RE: Project #1010181, PNM Richmond Switching Station  
Site Development Plan for Building Permit

Staff reviewed the October 9, 2014 version (v.3) of the site development plan for building permit and notes the following, minor issues:

RE: DRB Comment Responses – Project #1010181 – Richmond Switching Station

JLB	DATE: May 21, 2015
TMF	SCALE: 1"=50'
ACAD FILE: SBD-5802	SHEET 1 OF 6

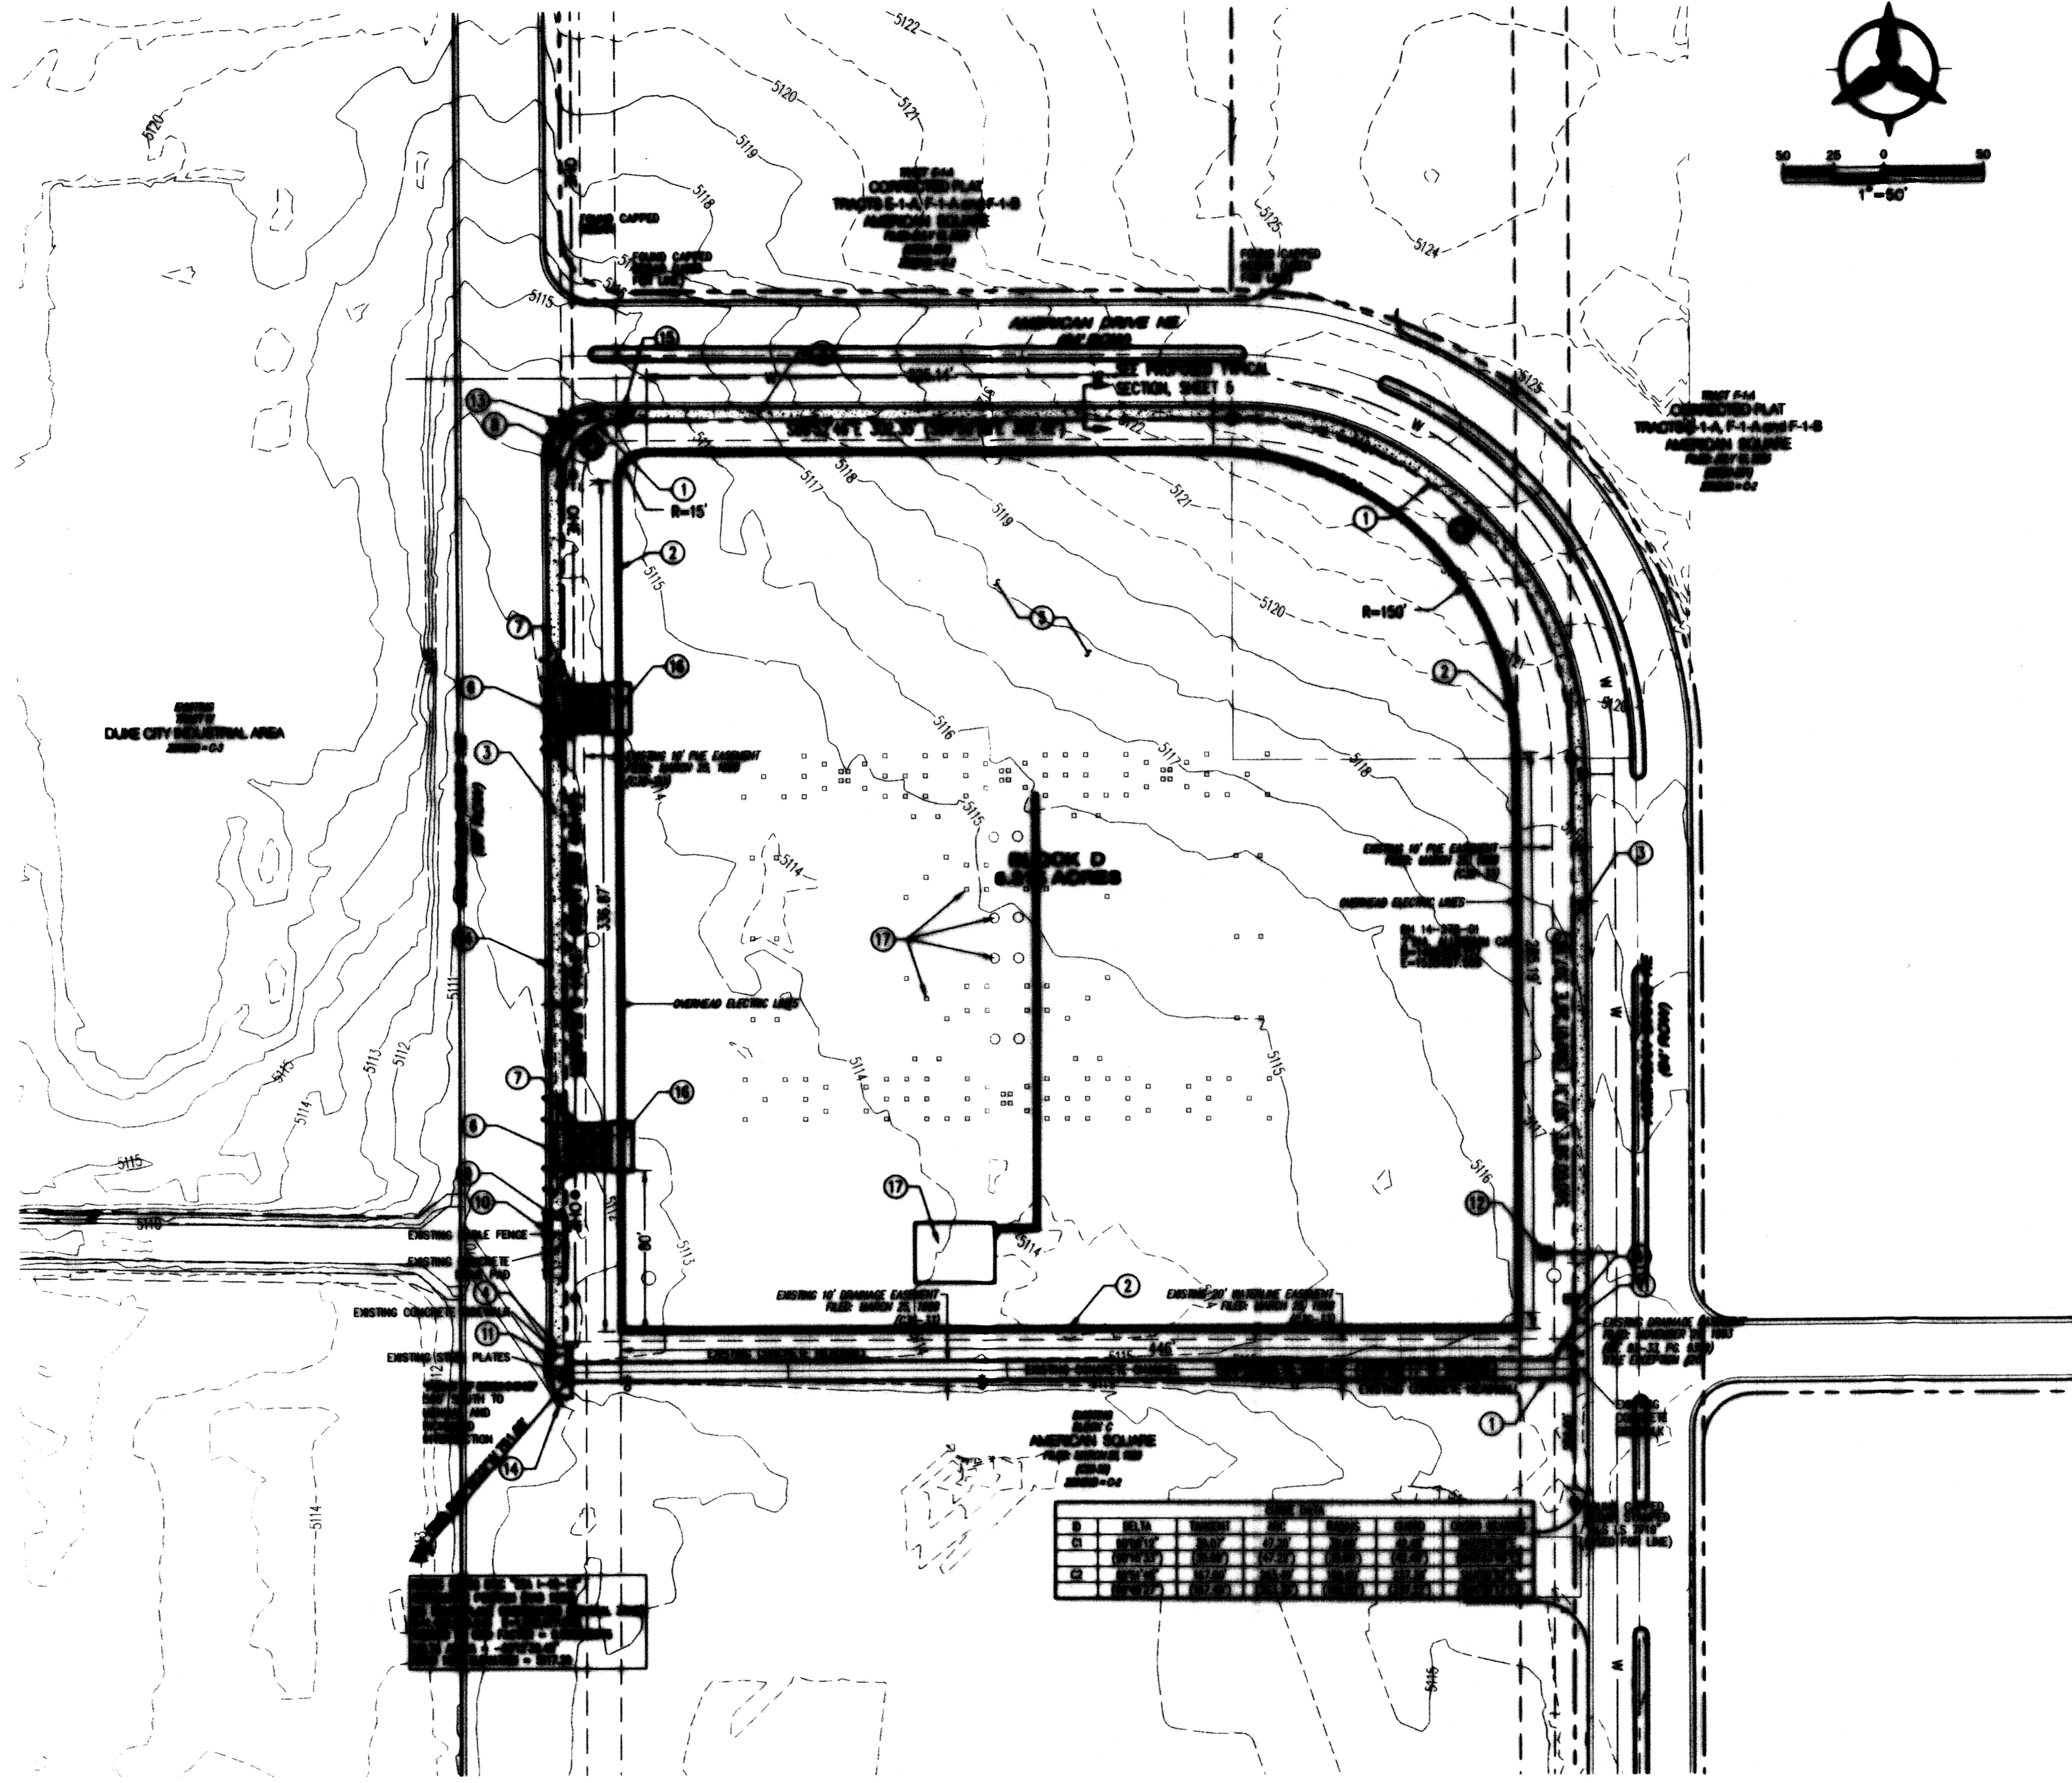
1. Sheet 1: Please re-instate keyed note 17, both the written note and the two instances where it is used to label equipment inside the switching station wall.

*Keyed Note 17 and the two instances where it is identified on the plan have been reinstated.*

DR: JLB **DATE:** Oct 09, 2014 **SCALE:** 1"=50' TMF ACAD FILE: SHEET 1 OF 6

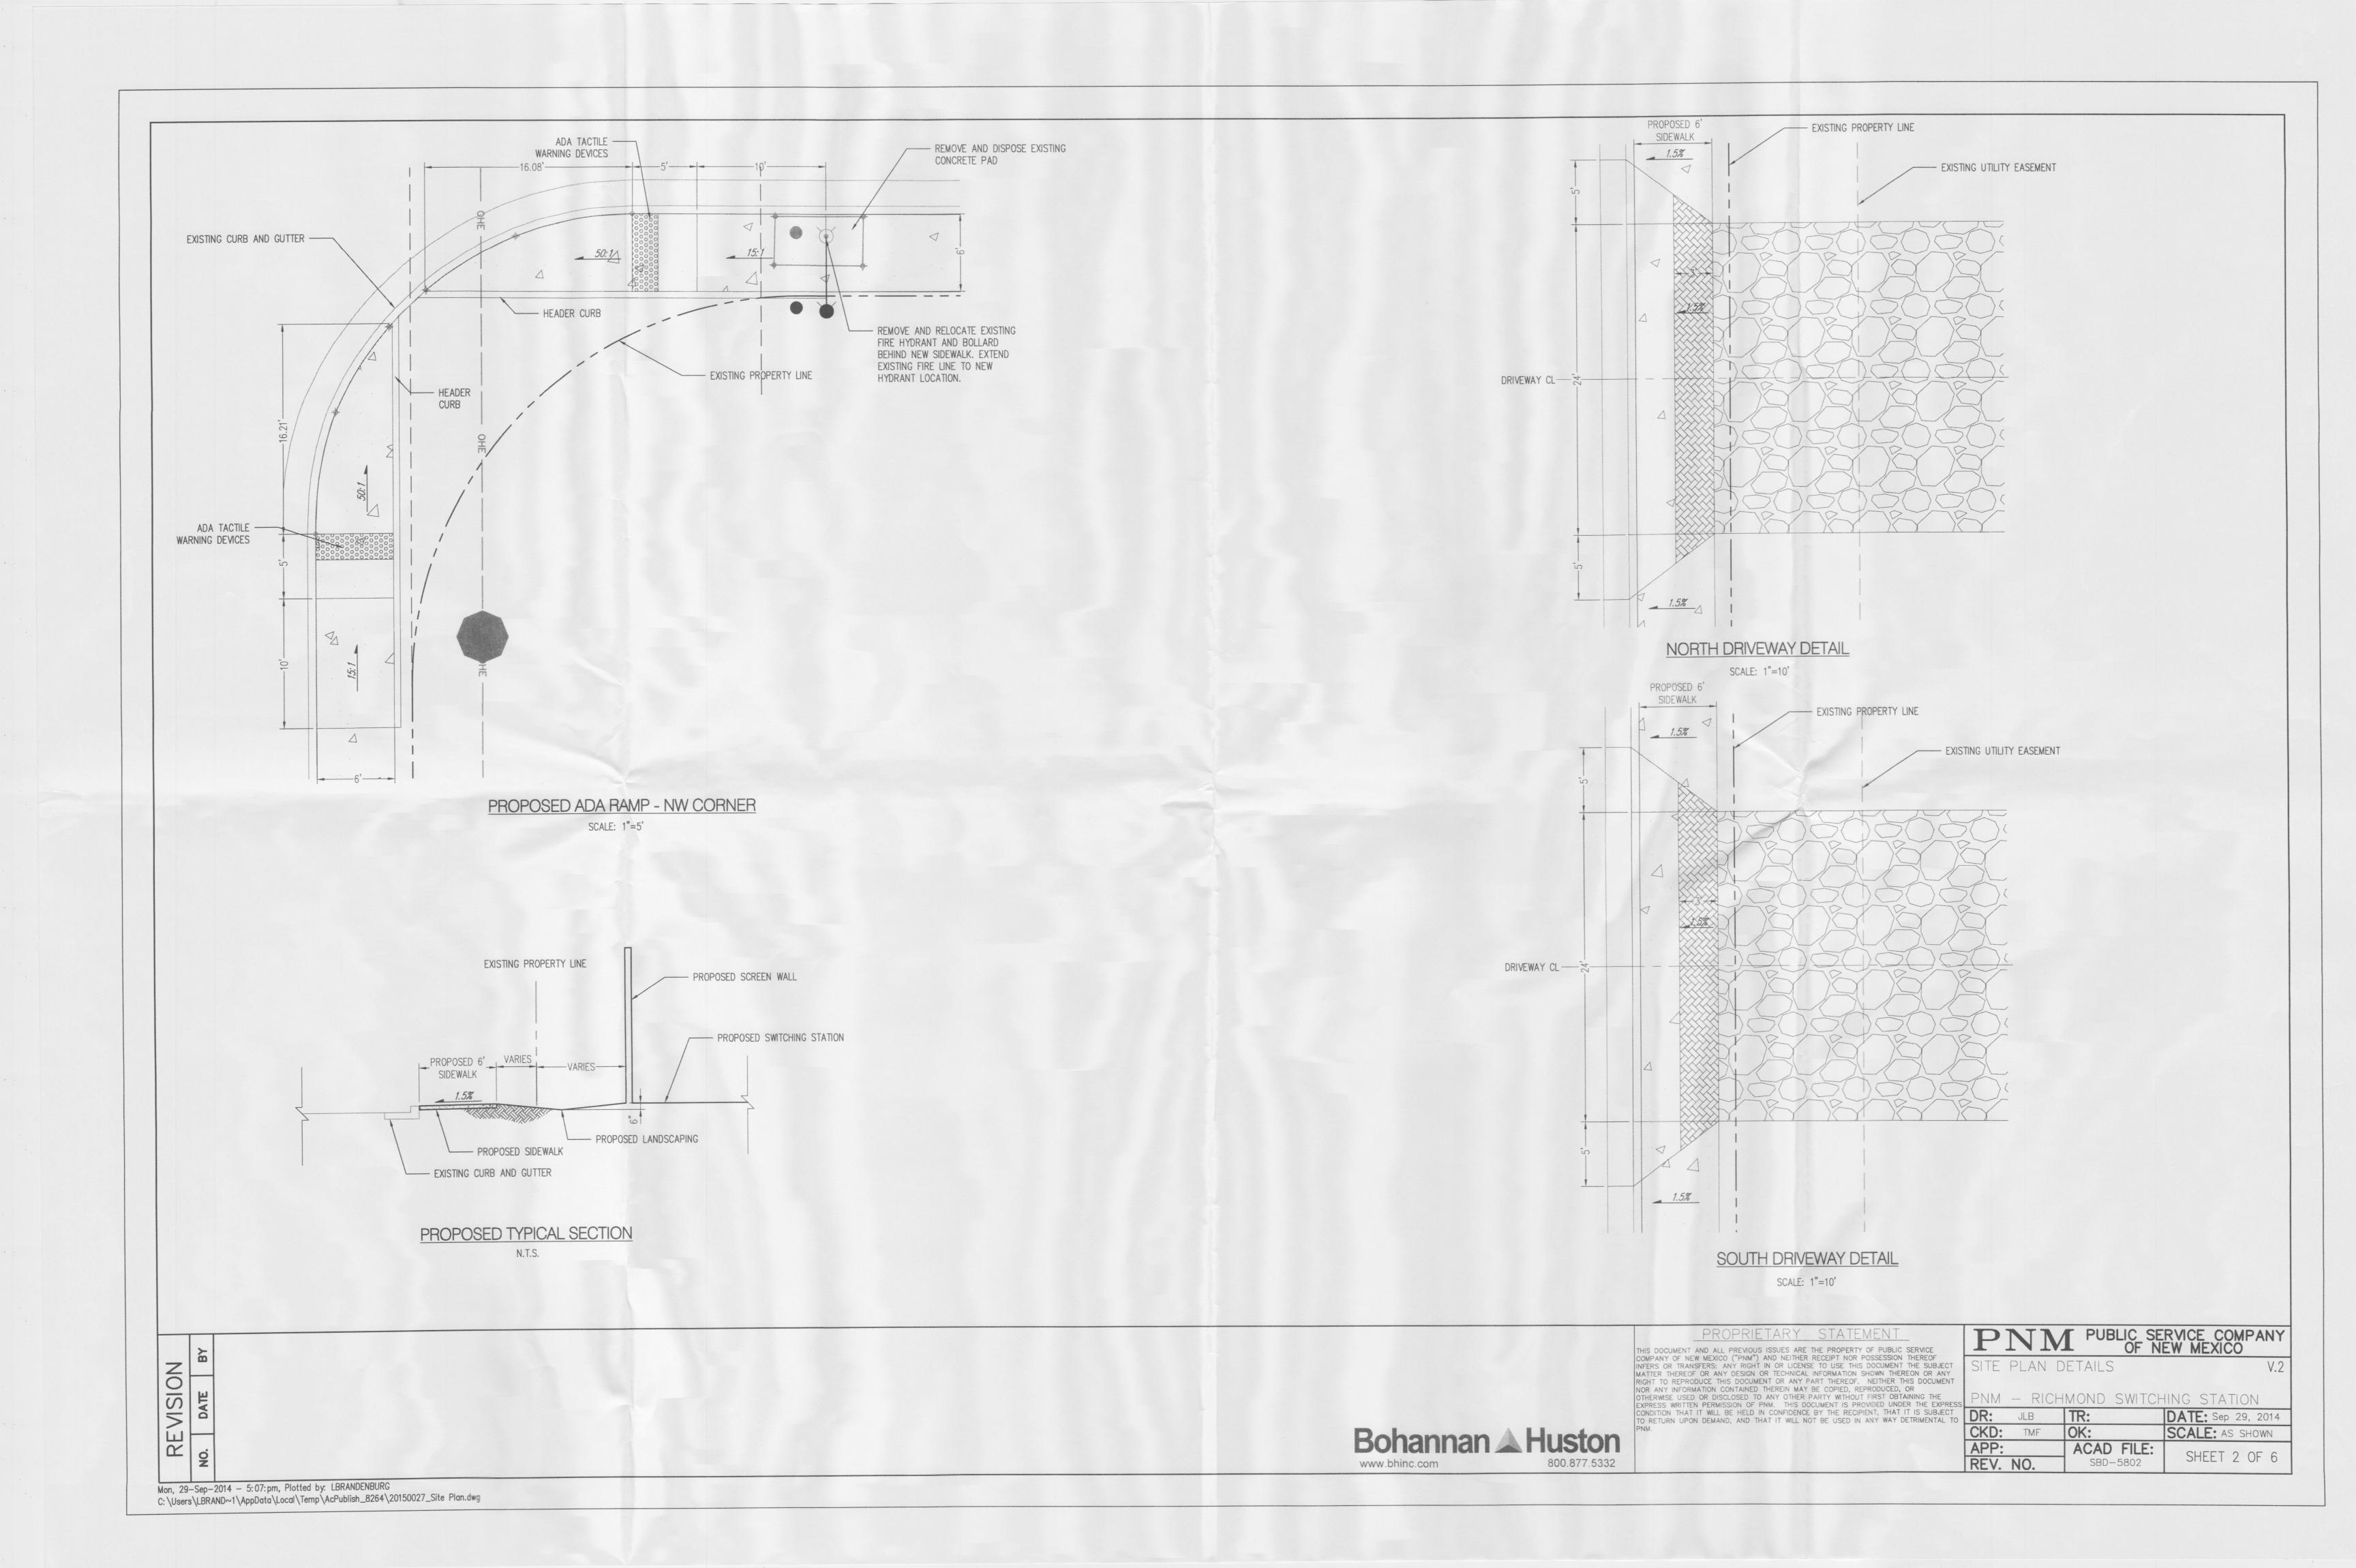
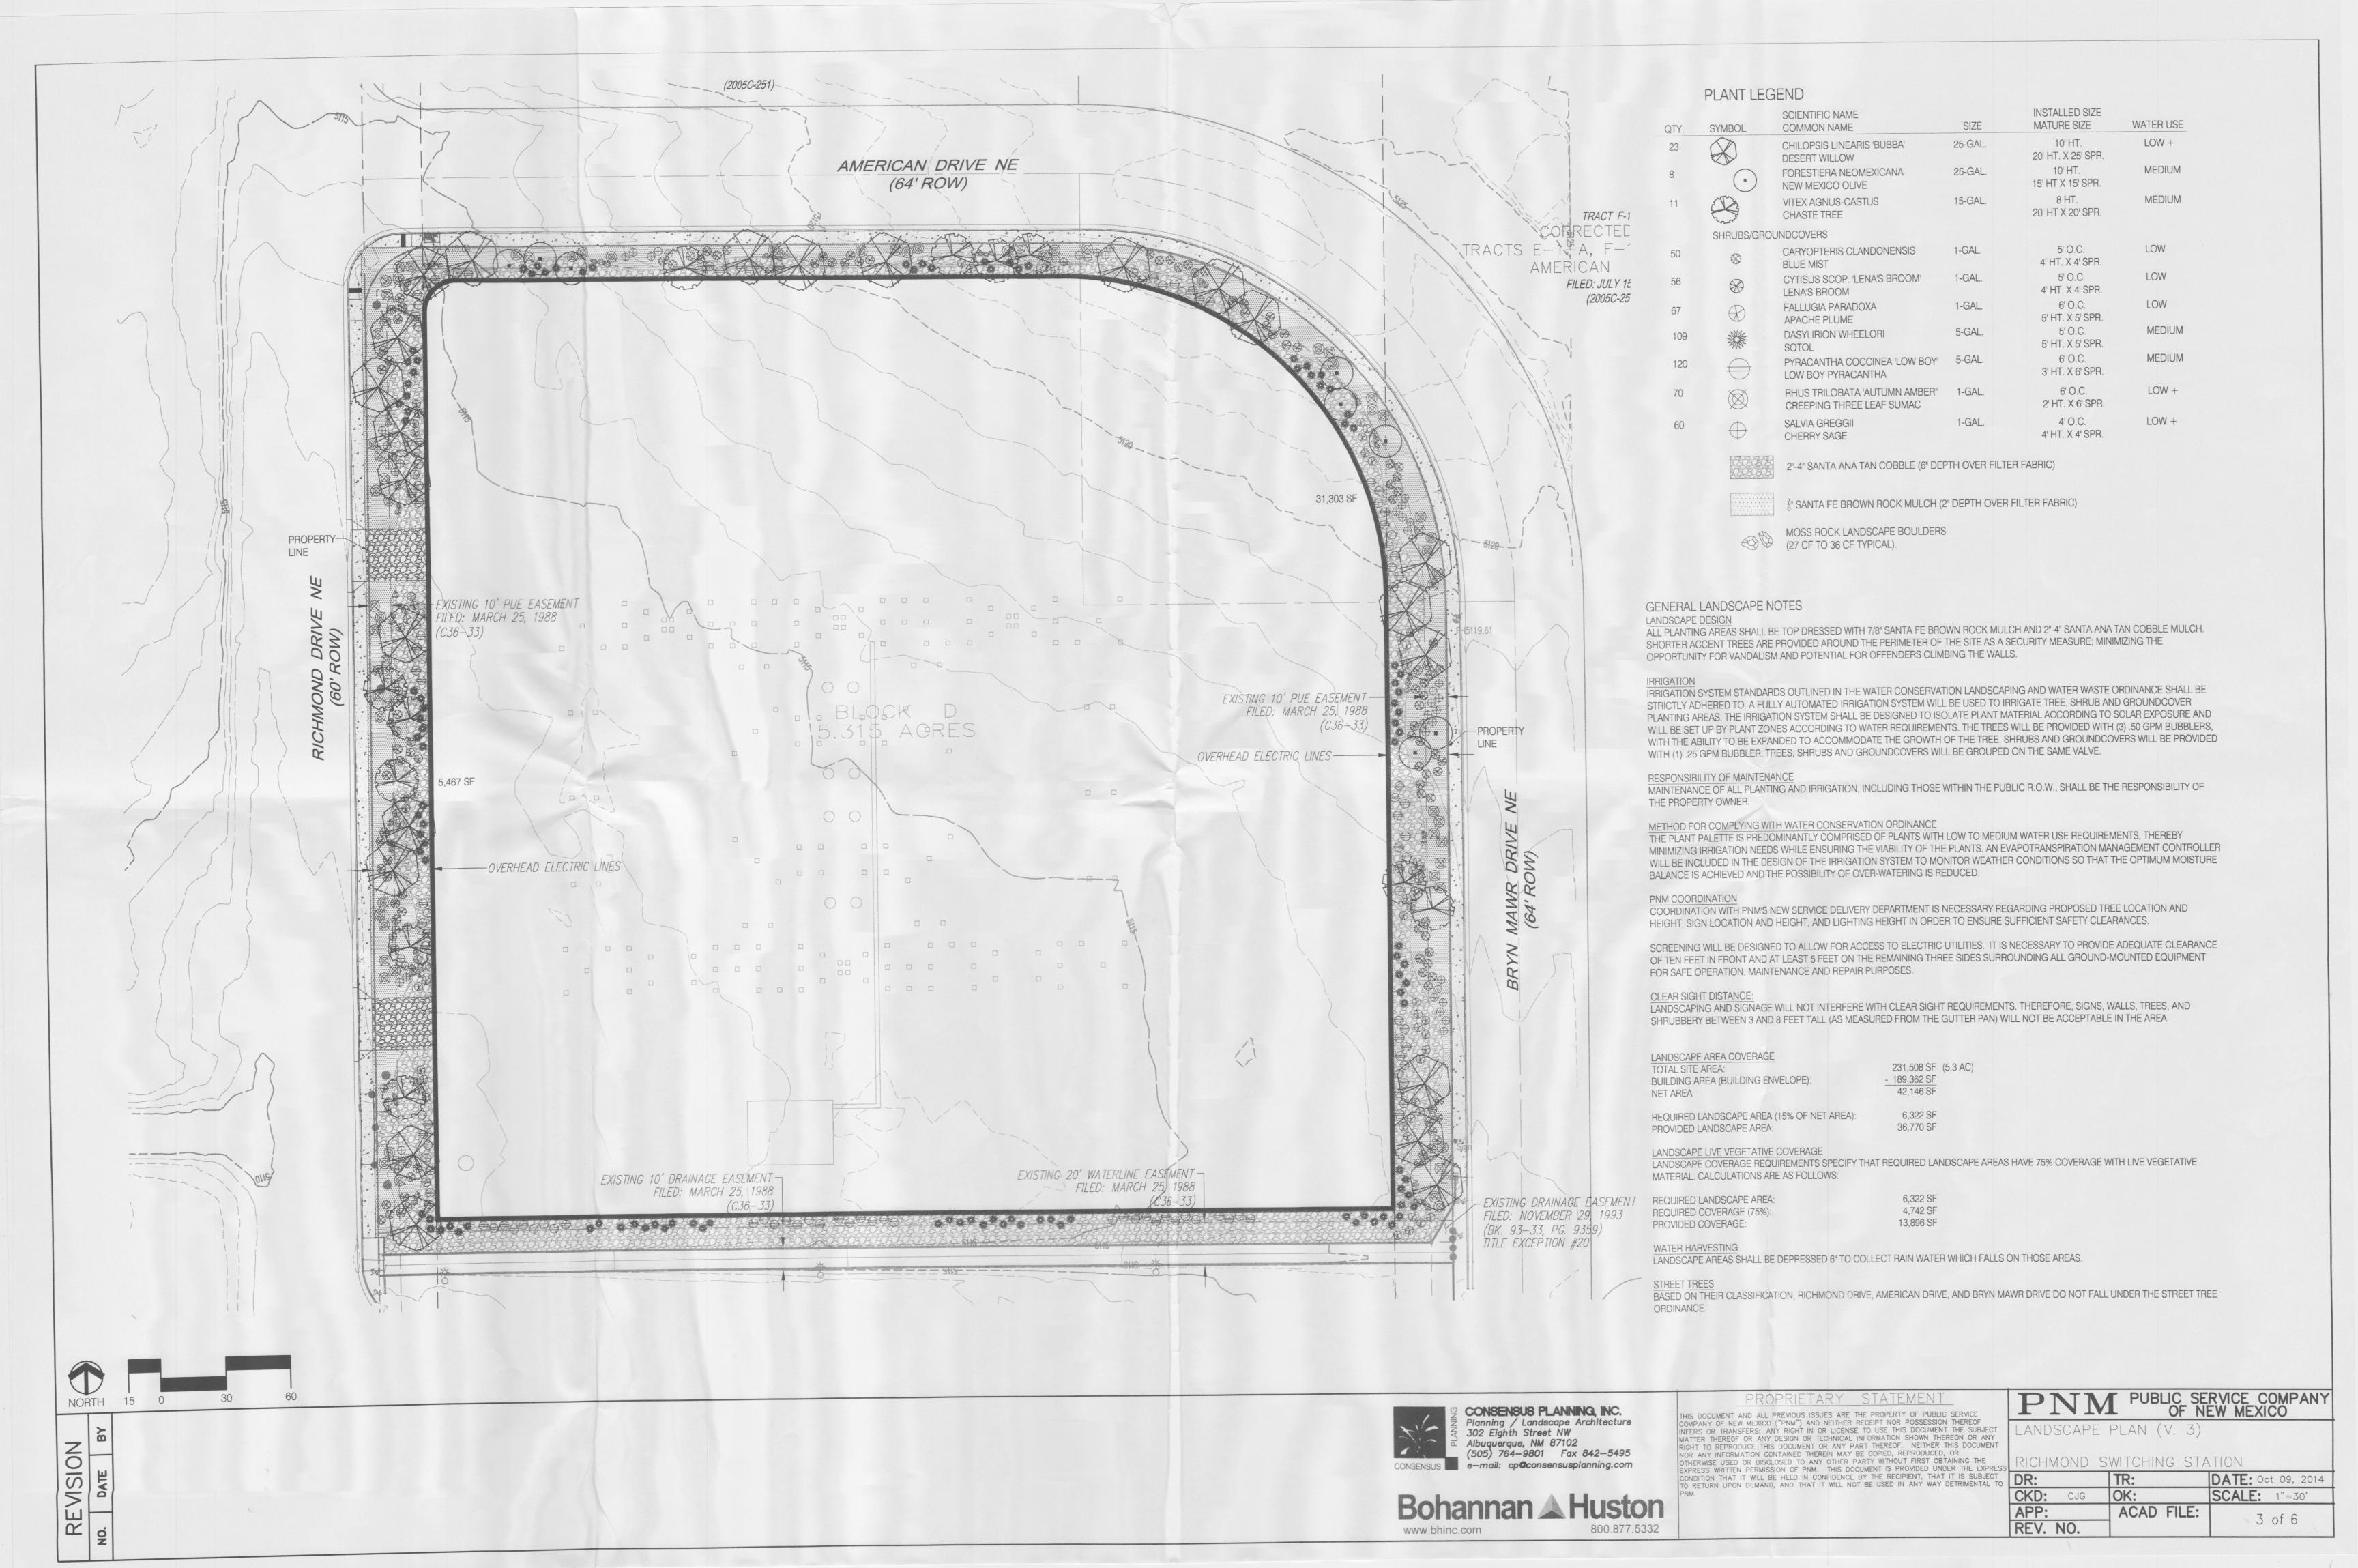
Please re-instate keyed note 17, both the written note and the two instances where it is used to label equipment inside the switching station wall.
